Appeal Decision

Appeal Ref: APP/R5510/D/24/3338583

48 Myrtle Avenue, Ruislip, Hillingdon, HA4 8RZ

- The appeal is made under section 78 of the Town and Country Planning Act 1990 against a refusal to grant planning permission.
- The appeal is made by Mr and Mrs Zakirov against the decision of the Council of the London Borough of Hillingdon.
- The application Ref 77167/APP/2023/2854, dated 27 September 2023, was refused by notice dated 30 November 2023.
- The development proposed is roof extension and loft conversion, 3 x roof lights to front elevation.

PROPOSED ROOF PLAN

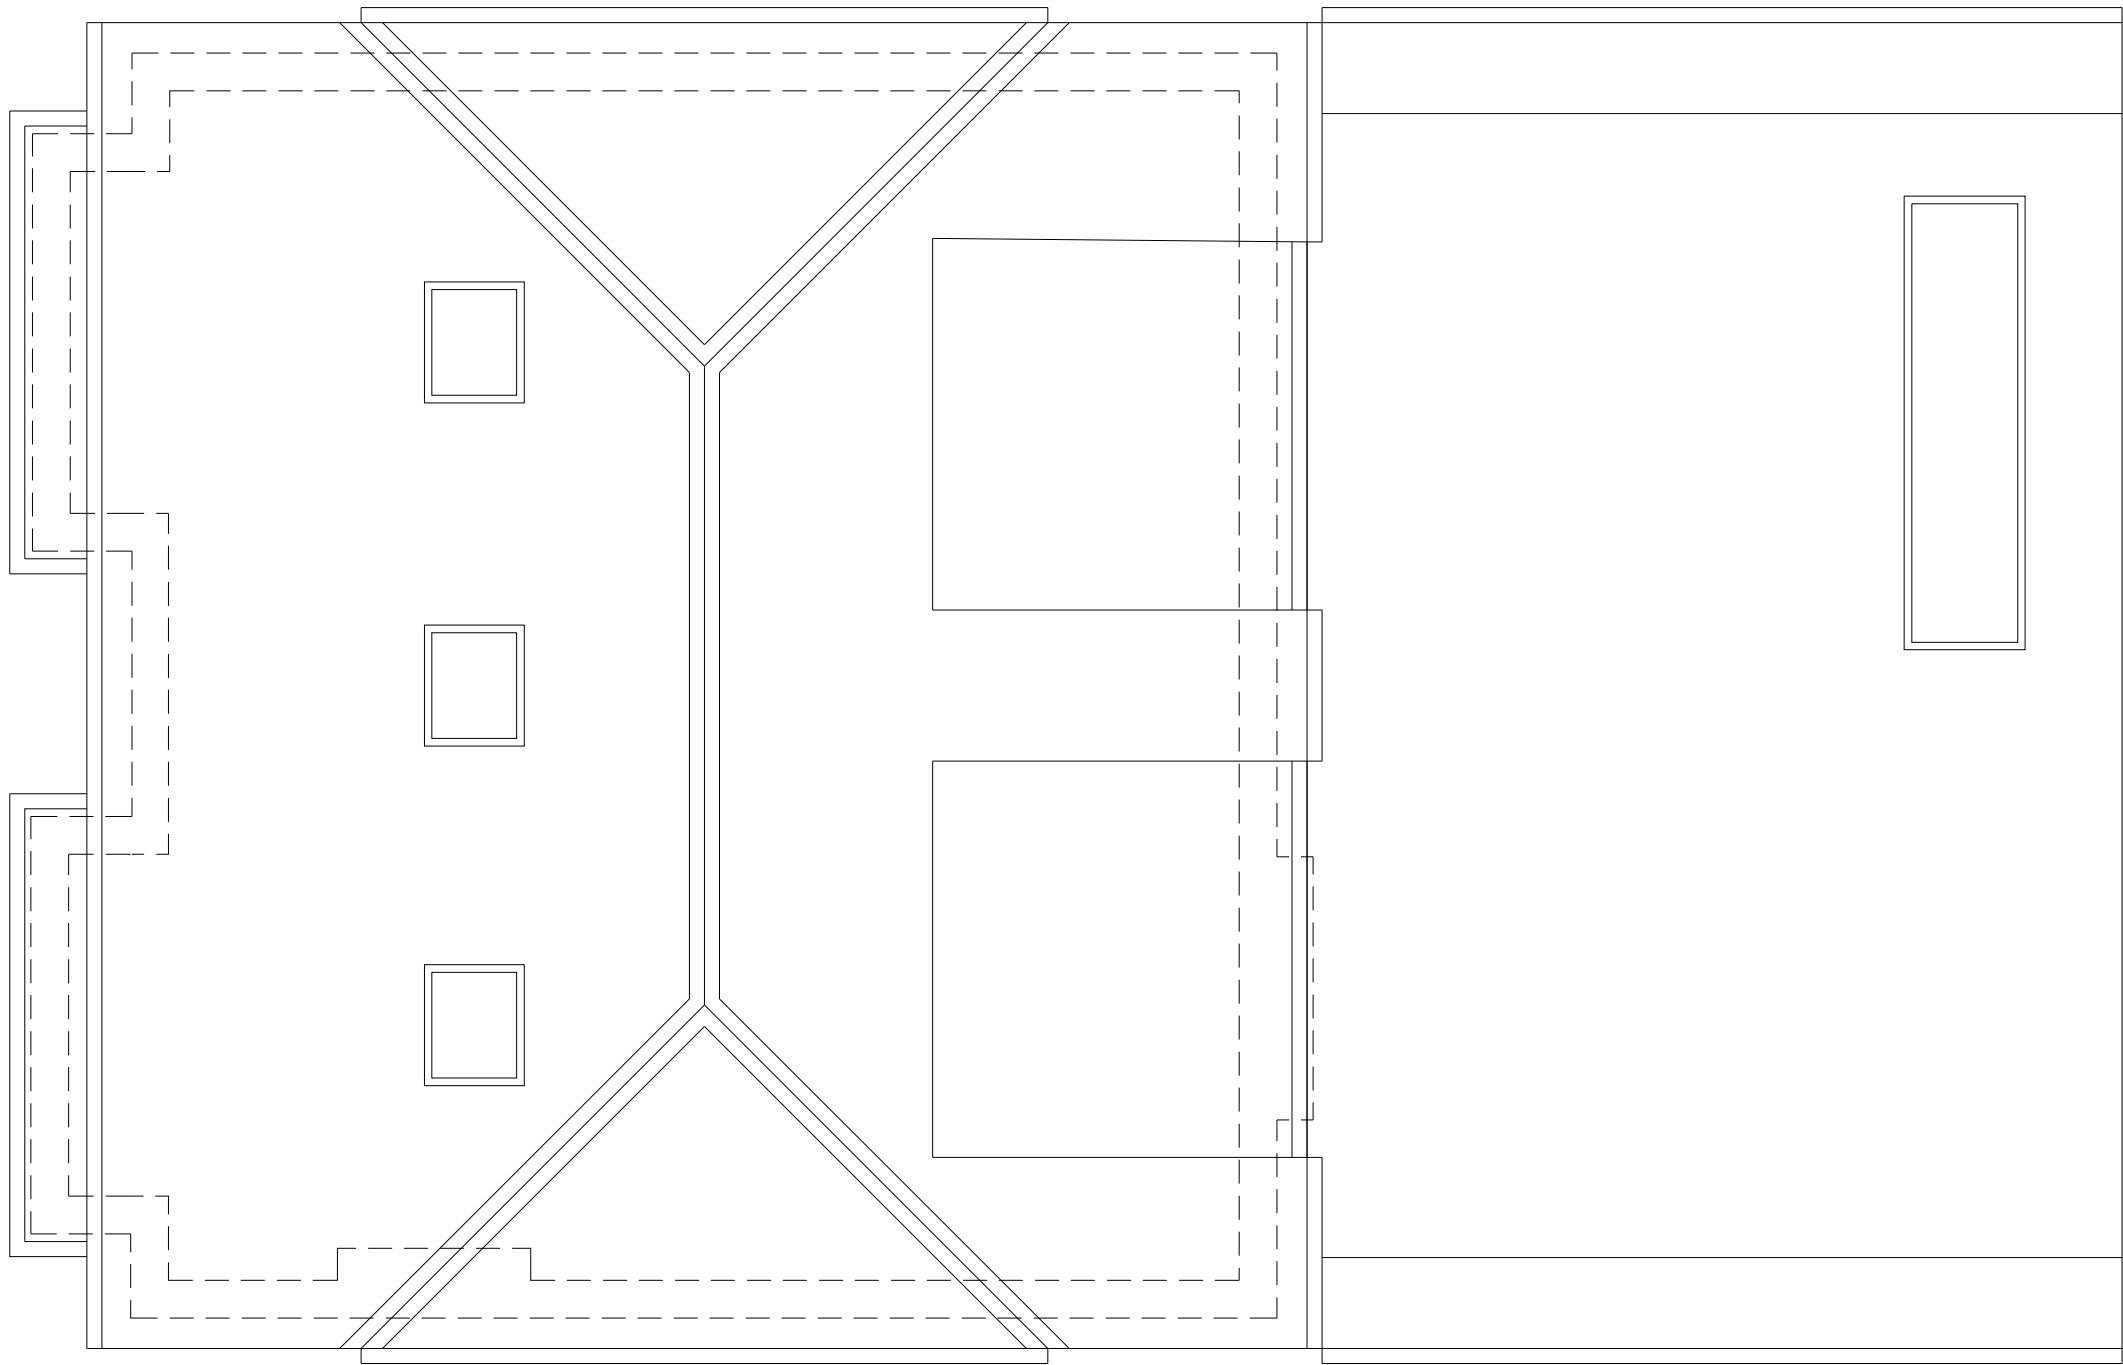
6. The proposal would not be strictly in accordance with local plan policy DMHD1 which states that raising a main roof above the existing ridge line of a house will not generally be supported. In this case, the increase in height is required to accommodate new habitable space in a bungalow and would be relatively modest. The half hips at either end would reduce the overall bulk and reflect a feature found in a number of rooflines along the street. The front slope of the proposed new roof, with a similar pitch to the existing and roof lights, would present a relatively simple, unfussy appearance to the street scene. The existing symmetrical form of the frontage would remain and the projecting bay windows would appear more clearly expressed than they are at present.

PROPOSED ELEVATIONS

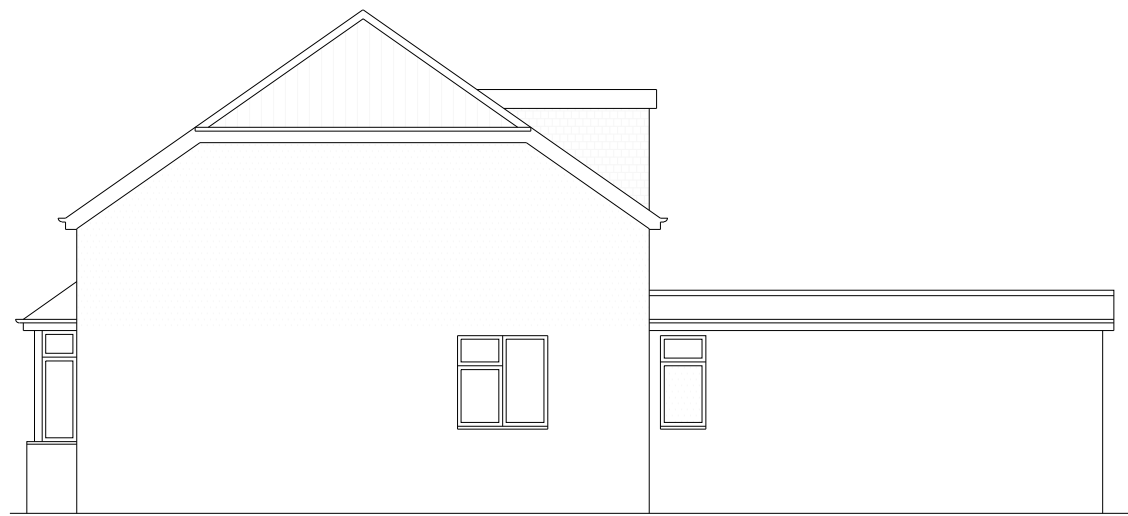
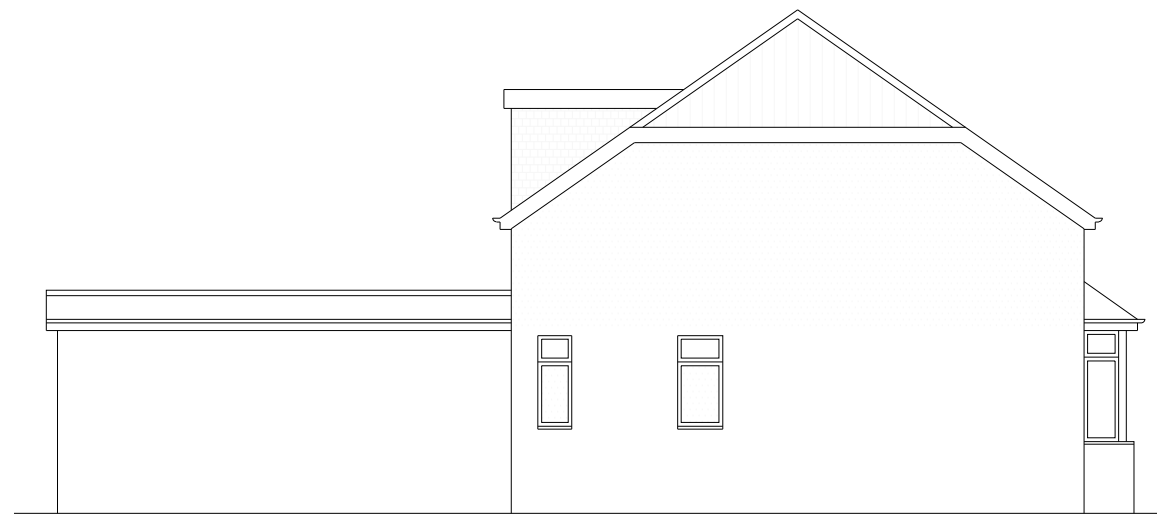
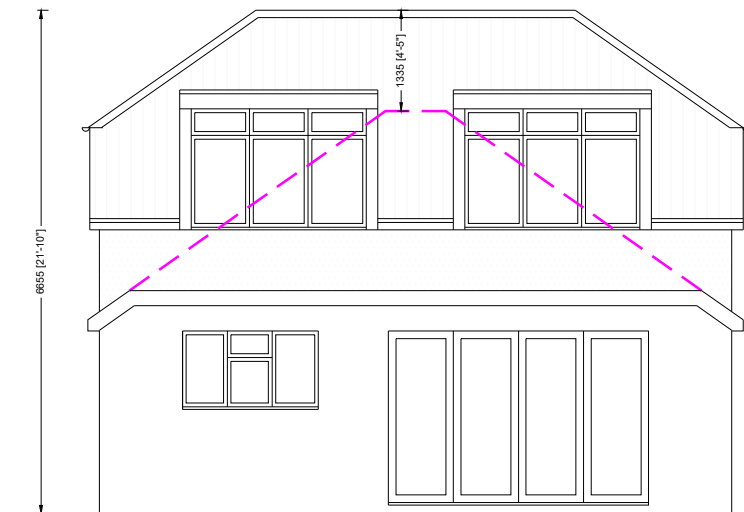
8. The rear dormers would be in proportion with the new roof form and set down from the new ridge and in from the sides and would include a large area of glazing. They would be visible in limited views from Warrender Park to the rear, but would be mainly screened by the high rear boundary fence and the trees and other vegetation in the Park especially when in leaf. They would appear in the context of several other prominent large rear dormers.
